CD V_1.pdf Markup Summary

PUDSP-16-01
EGP-18-002

Drainage Report V_1.pdf Markup Summary

GEC Plan V_1.pdf Markup Summary

DEVELOPED CONDITIONS  
DRAINAGE PLAN  
LORSON RANCH EAST FILING NO. 2

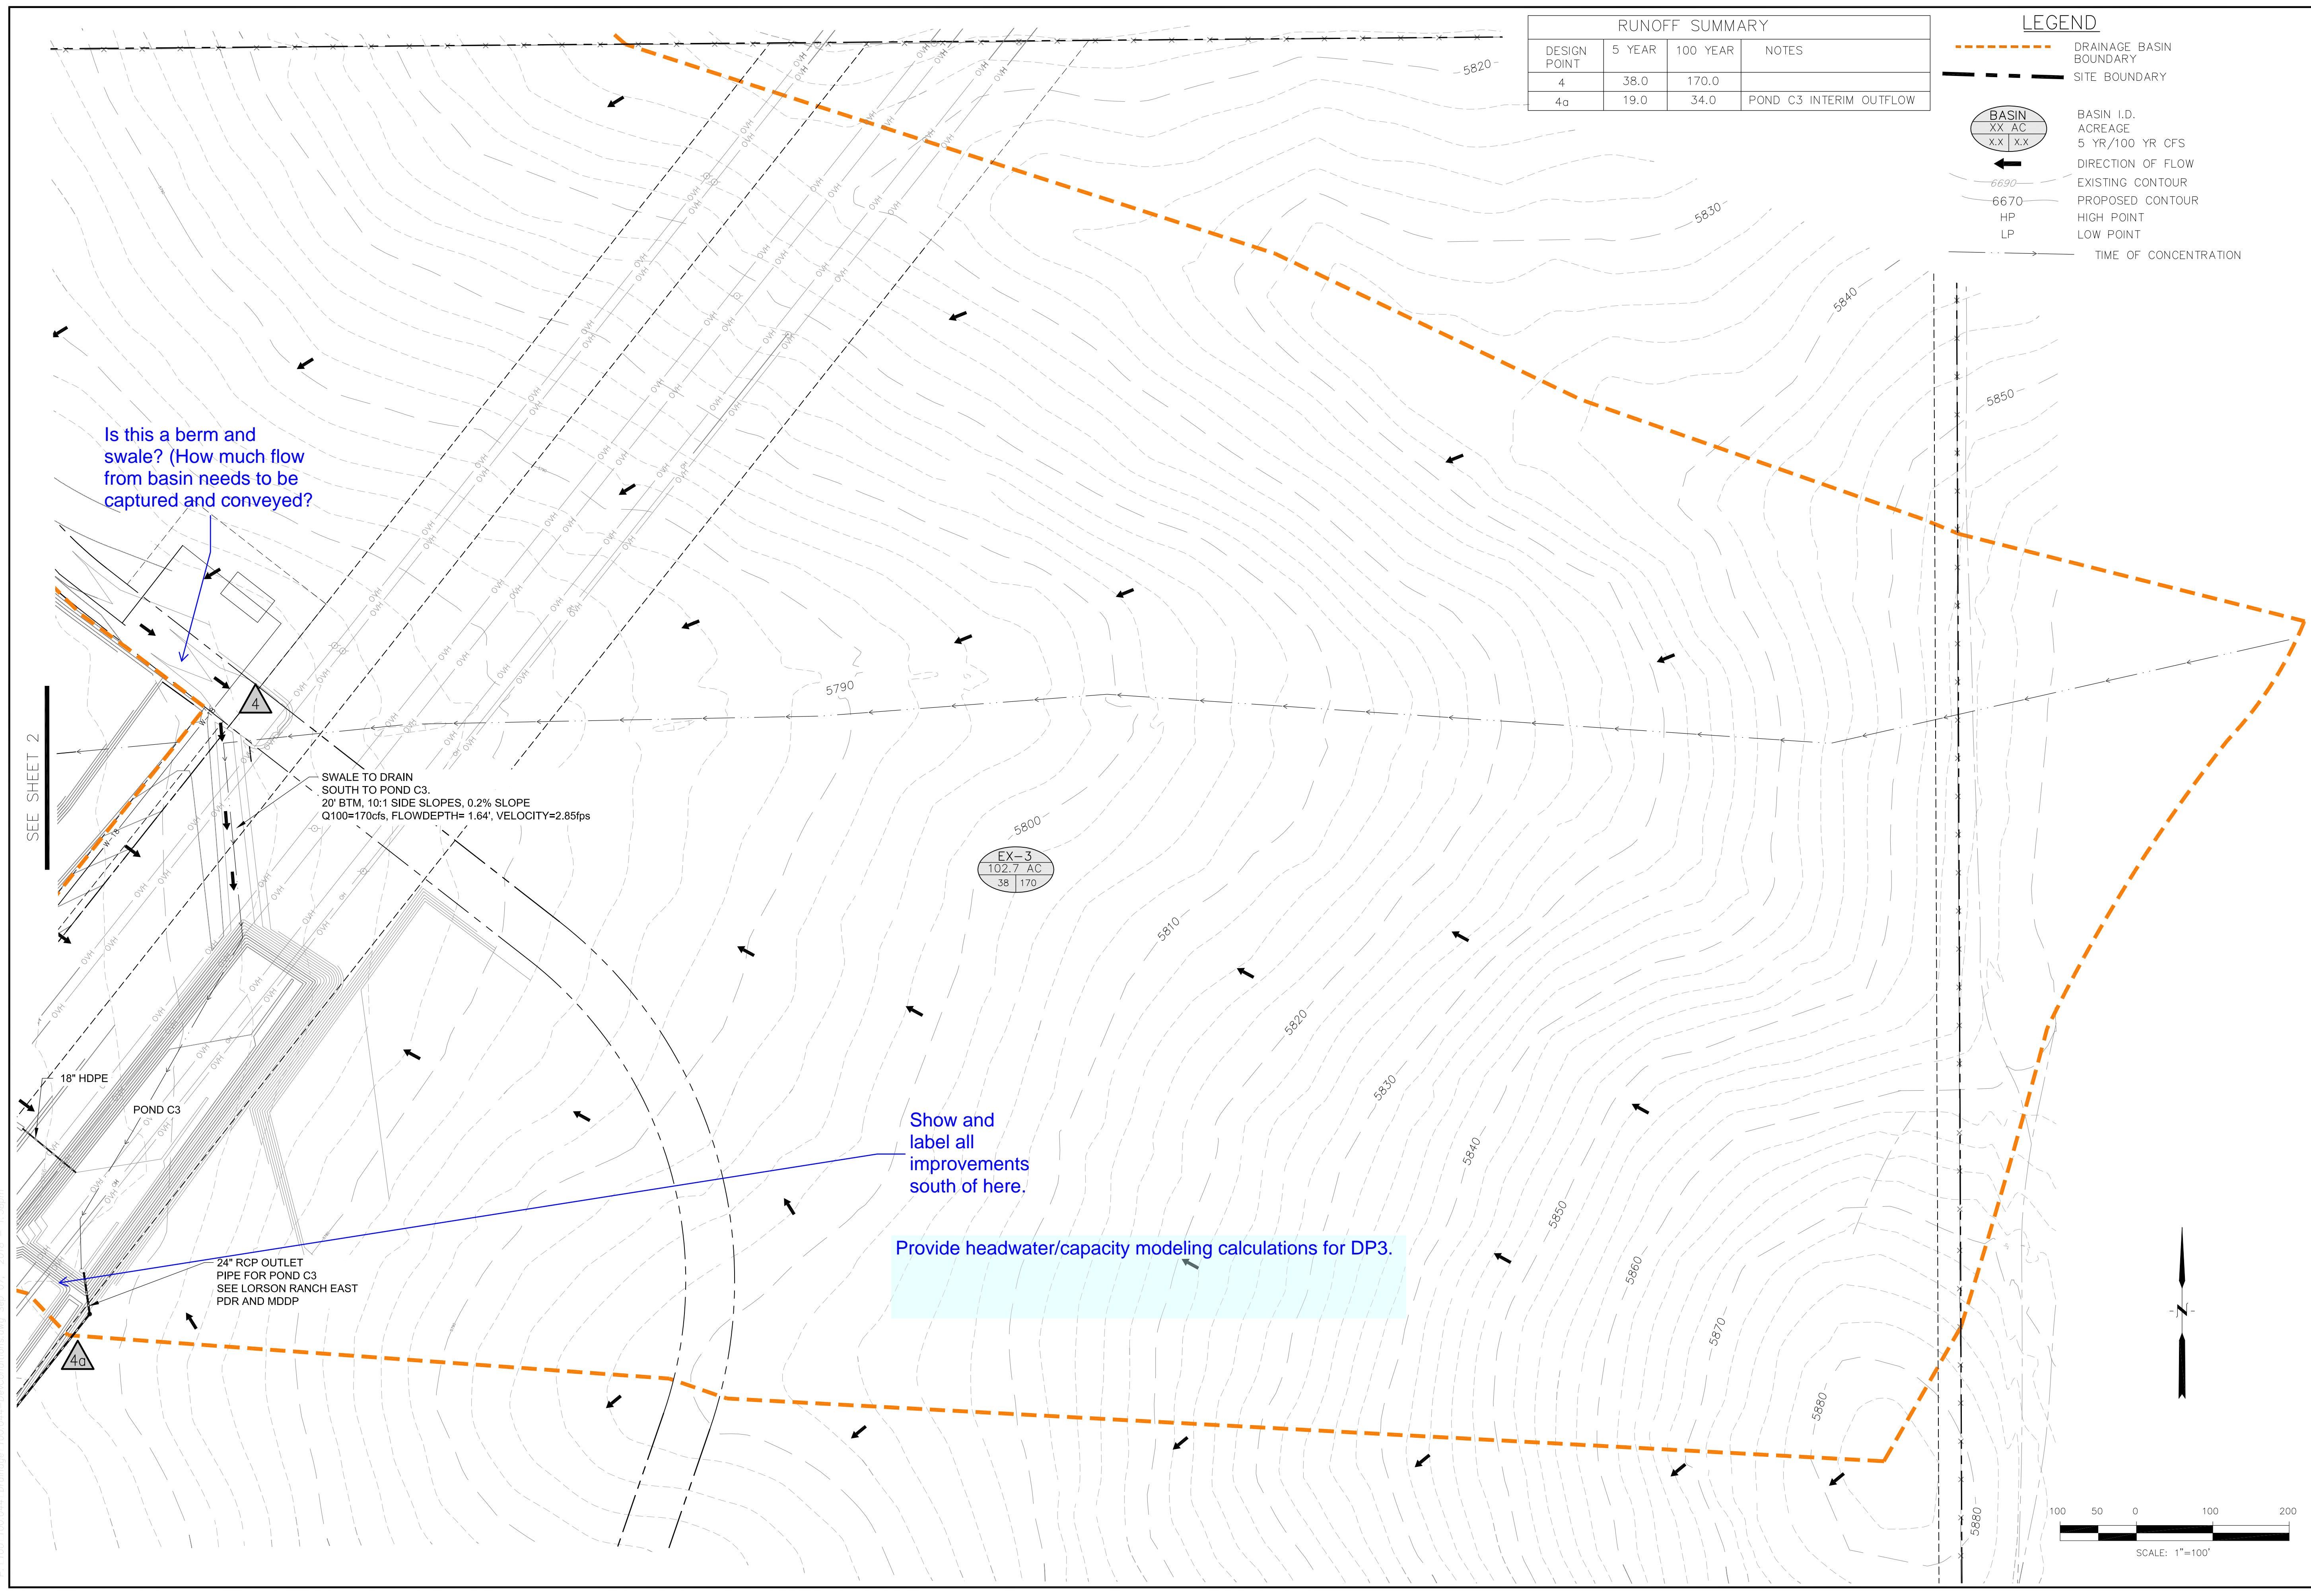
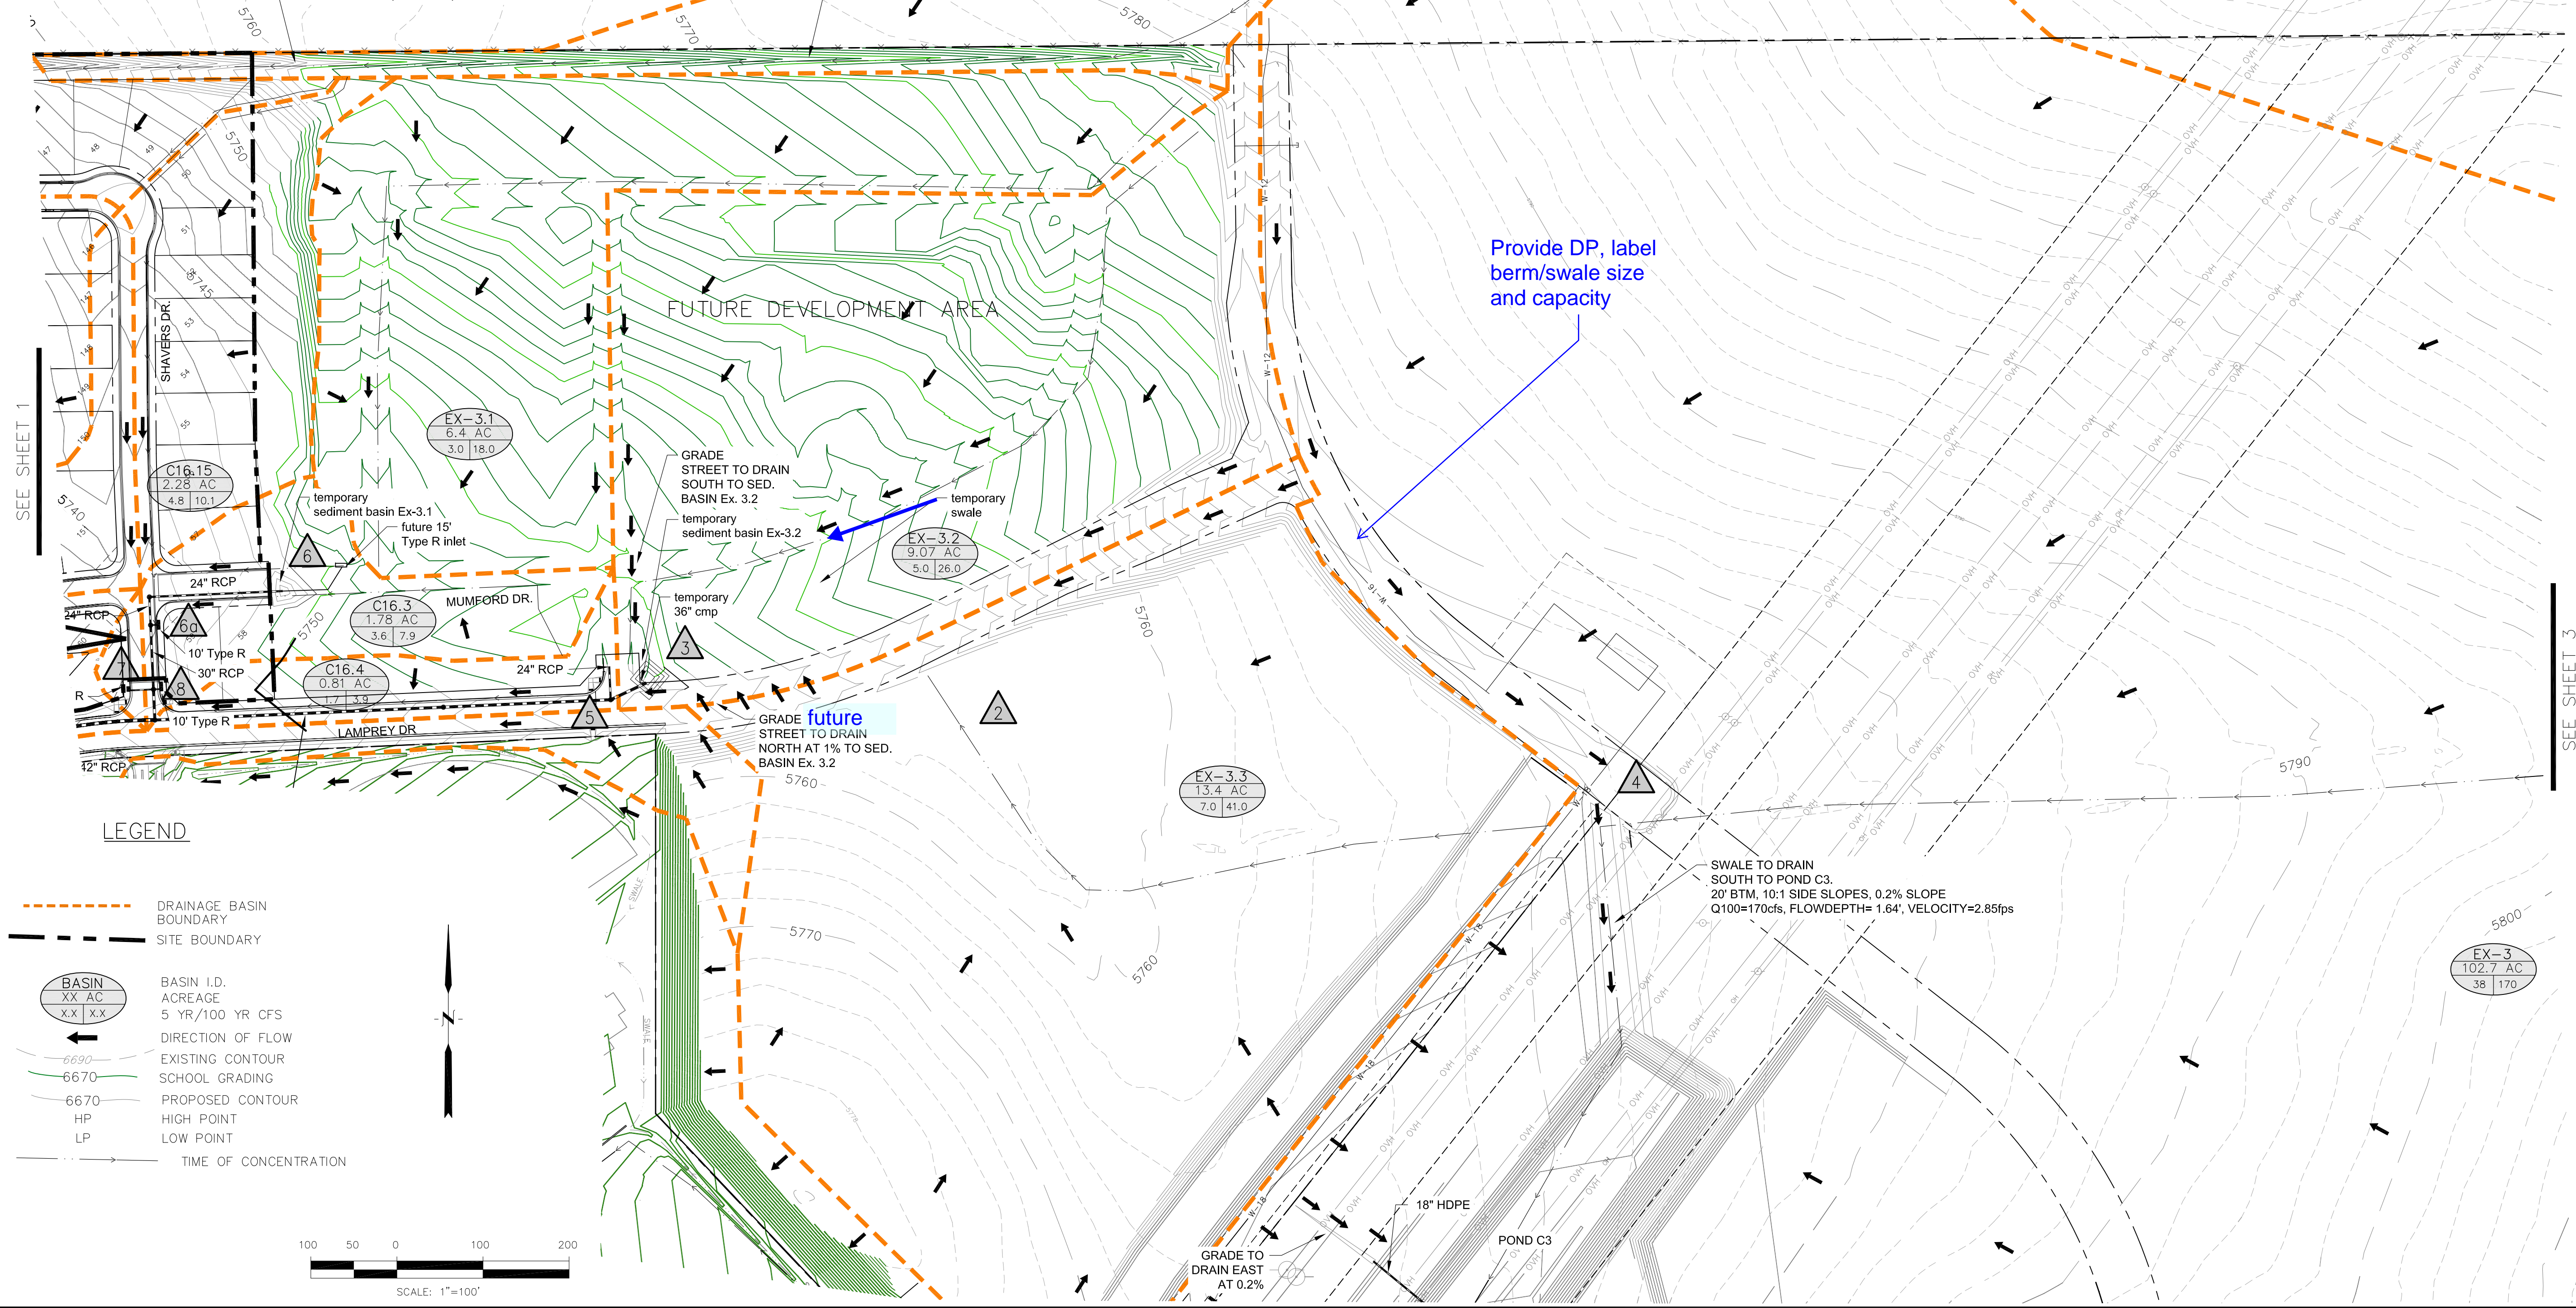
Label each slope separately.

label inlet

Is this area 6.5%?

Show and label 26-foot wide grass buffer strip

4%?

TRM
